CITY OF ALBUQUERQUE

RE: **Musket Development**
1615 8th St NW
Grading and Drainage Plan
Engineers Stamp Date 10/6/15 (J14D175)

MUSKET DEVELOPMENT 1615 8th STREET NW		DRAWN BY
	GRADING AND DRAINAGE PLAN		pm
	TERRA WEST, LLC 5571 MIDWAY PARK PL NE ALBUQUERQUE, NEW MEXICO 87109 (505) 858-3100 www.tierwestllc.com		DATE
			10-22-15
			DRAWING
			2015014-GR
			SHEET #
			GR-1
			JOB #
			2015014

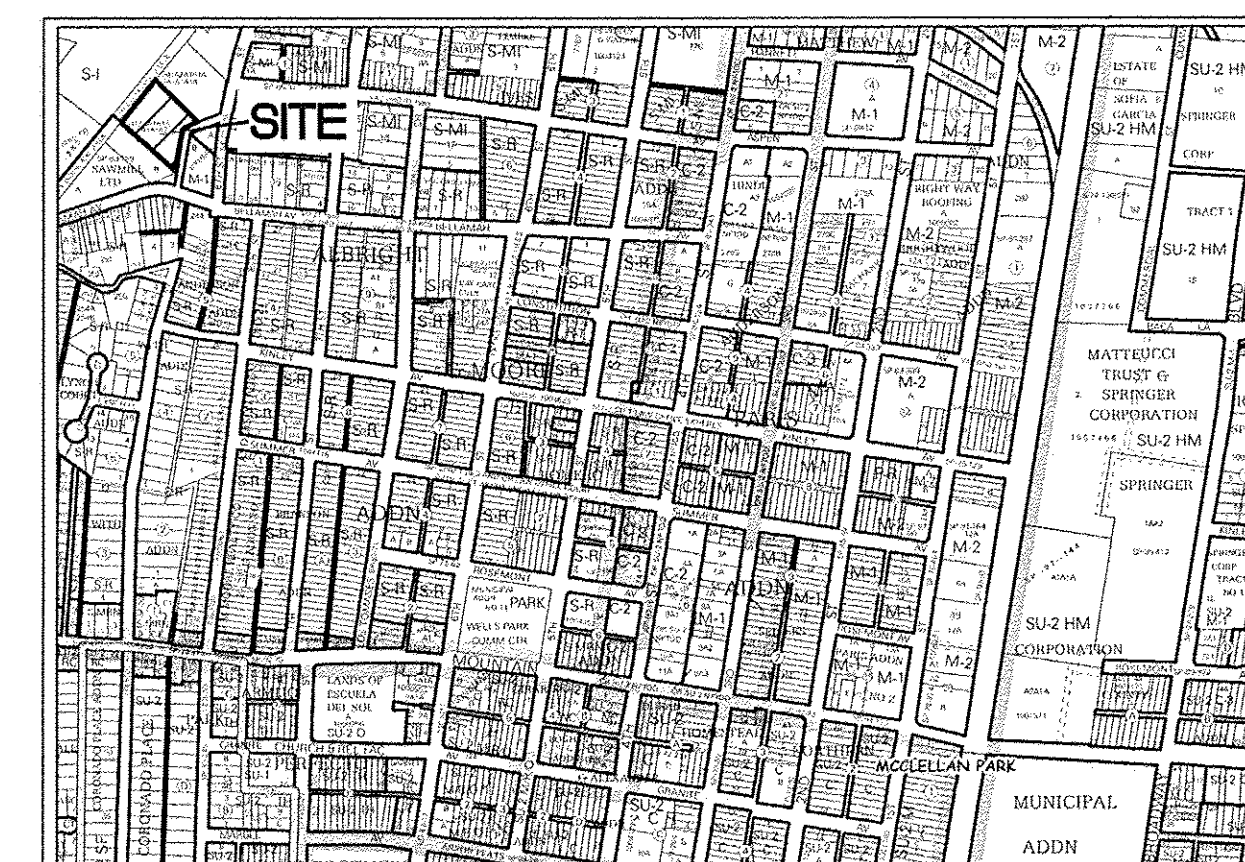
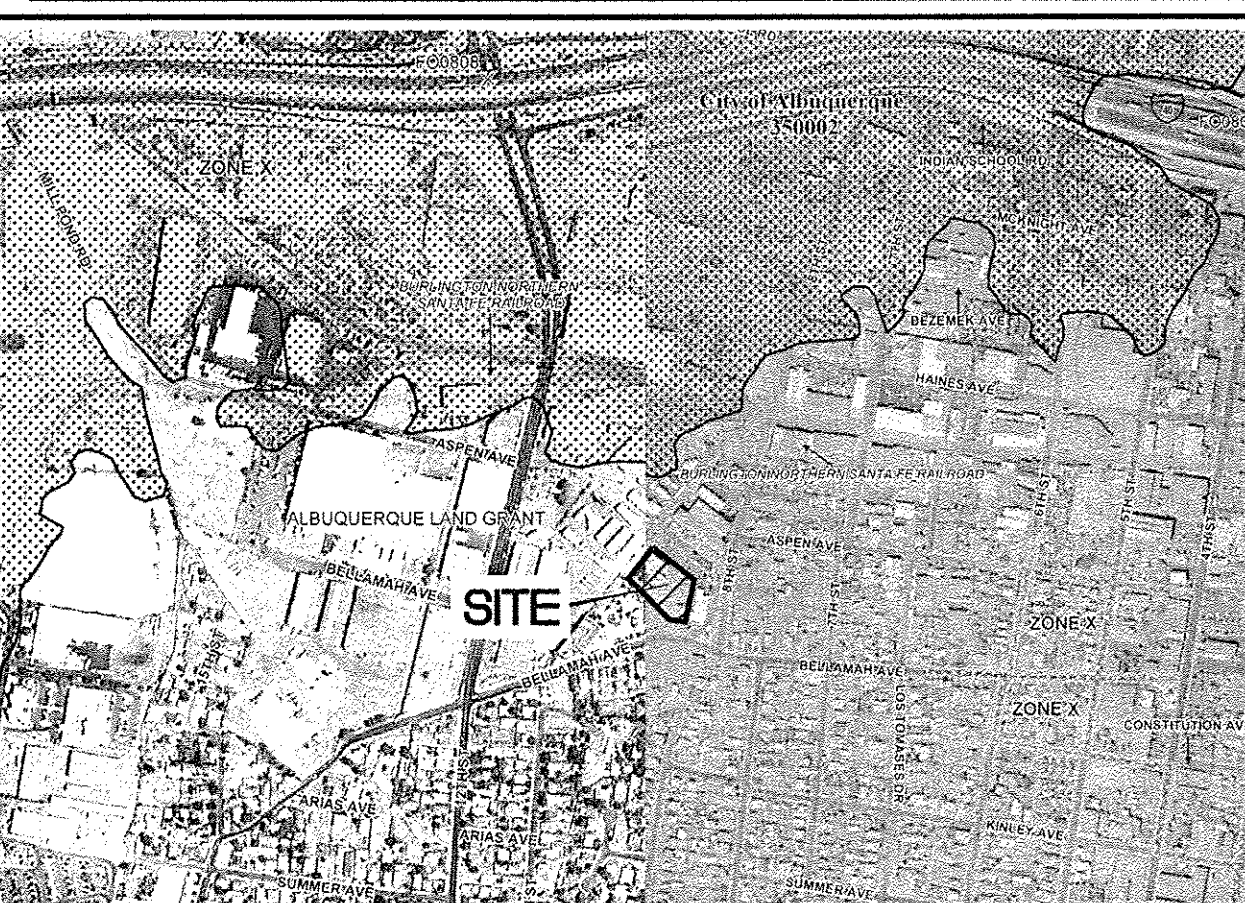
- Provide how the First Flush Pond in section A-A will drain to the east and west. It appears this pond will overflow at the east end which has a top of curb at 61.3 and the west end top of curb is 62.10.

- Flows from the south side roof and paving around the building need to be directed toward the first flush pond.
- Is the swale at the rear of the building continuous? If the swale is continuous how will access to the train car be addressed?

- Provide new calculations for the impervious areas.
- Provide pond bottom and water surface elevation.
- Provide an emergency over flow for the pond to the north of the building, directing flows toward the front of the building.

- Does the 8"cmp provide enough capacity for the flows entering the pond?
- Provide if the railroad tracks has an existing easement. If so, does the owner have approval for the pond in this location with the two 8" pipes under the tracks?
